17 November 2020

**Subject: Cowal Gold Operations Underground Development –
SSD-10367**

Thank you for referring SSD-10367, Cowal Gold Operations Underground Development to Forbes Shire Council for comment on the proposal. Council notes that unfortunately the SEARs were not referred to Council for comment.

Preferred transport routes

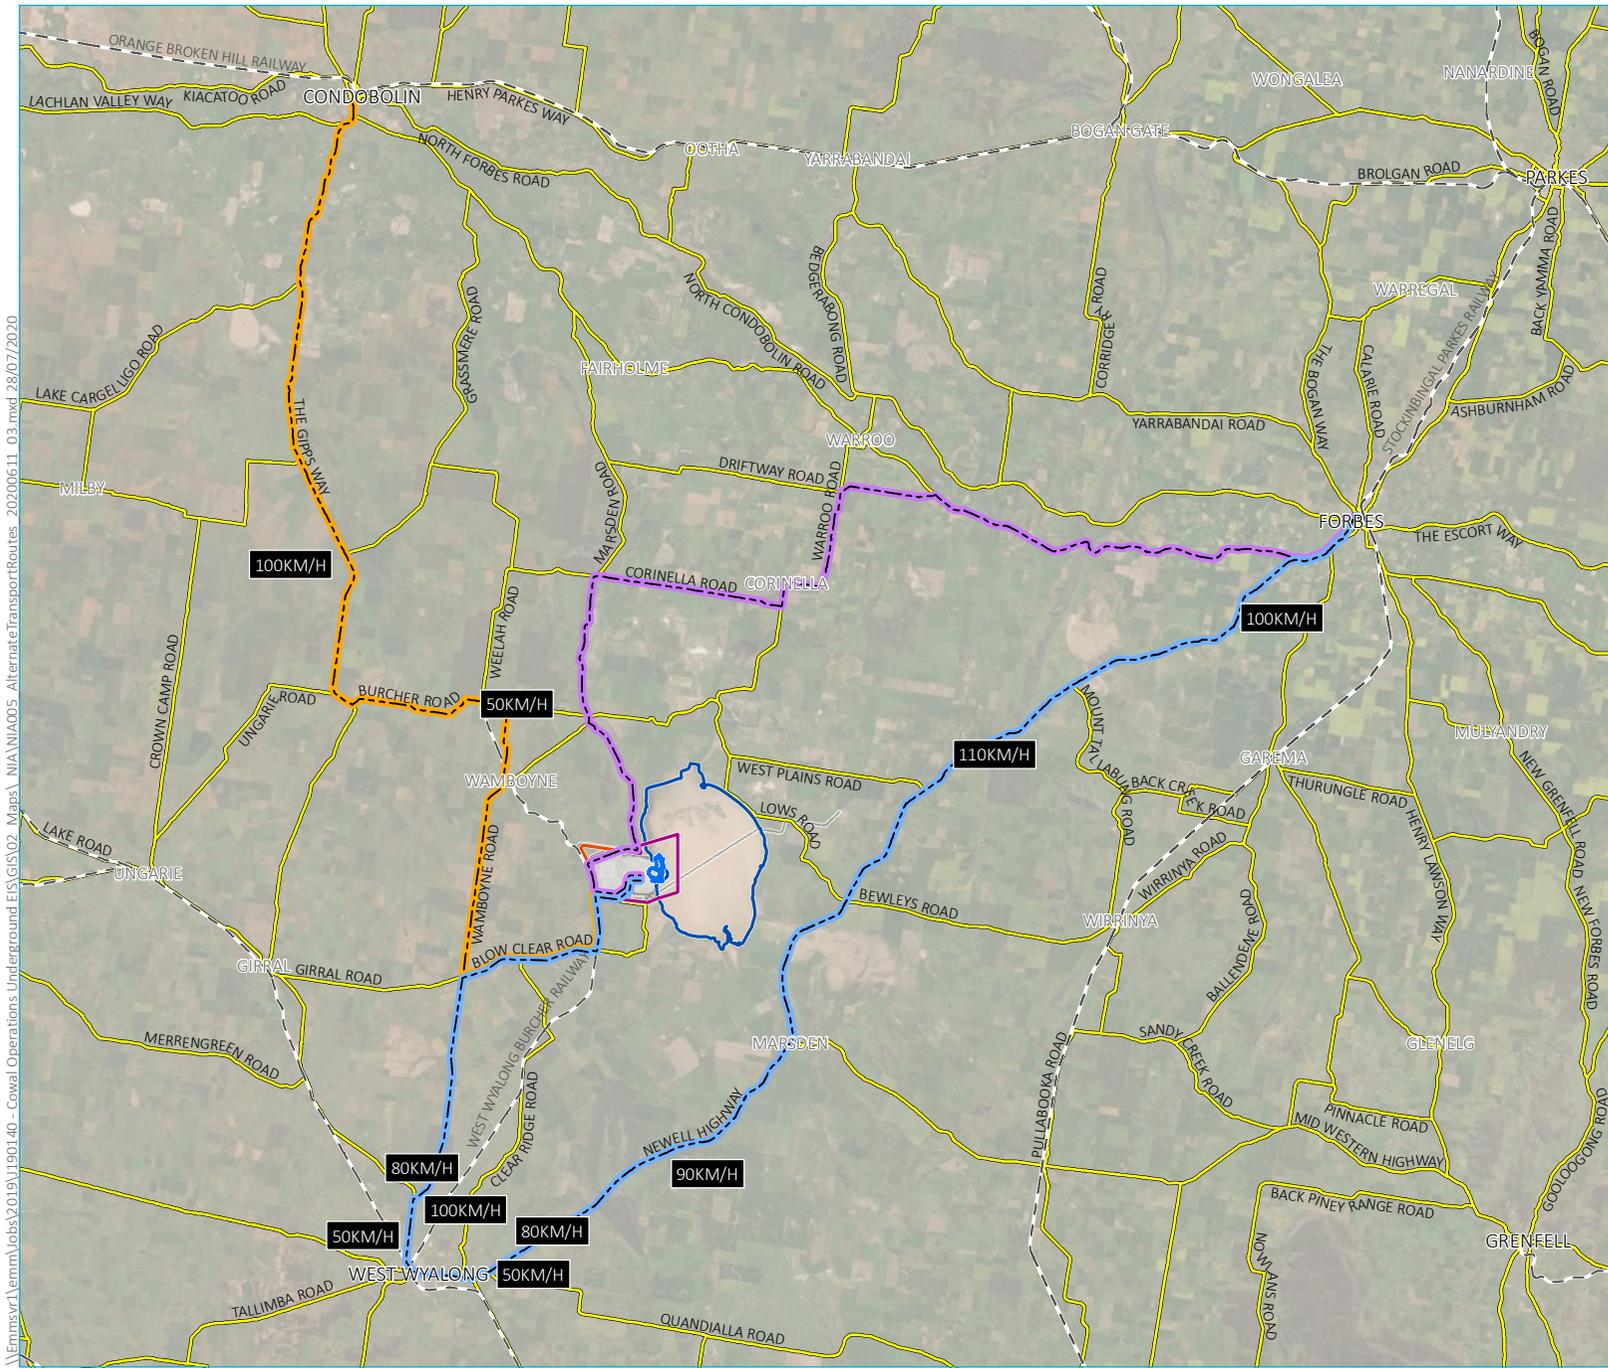
The EIS lacks details around preferred traffic routes from Forbes to the development site and whether these are suitable.

The existing transport route to Cowal Gold Mine is down the Newell Highway, turning right onto West Plains Road which is an unsealed road and following along to Bogies Island Road to the development site. The formation of West Plains Road has deteriorated due to the increase use by Cowal Gold Mine employees. The additional traffic movements proposed as part of this development application warrants transport upgrades along this route for the benefit of the mine as well as the wider community within this localised area.

- Prior to the commencement of any onsite construction work the intersection of the Newell Highway and West Plains Road are to be upgraded to provide a Basic Right Turn (BAR) treatment and Basic Left Turn (BAL) treatment to the satisfaction of Transport for NSW and Forbes Shire Council and in accordance with *Austrroads Guide to Road Design*.

- Prior to the commencement of any onsite construction work upgrade the entire length of both West Plains Road and Bogies Island Road to a bitumen sealed two-way, two-lane road to the satisfaction of Council and in accordance with *Austrroads Guide Road Design*.
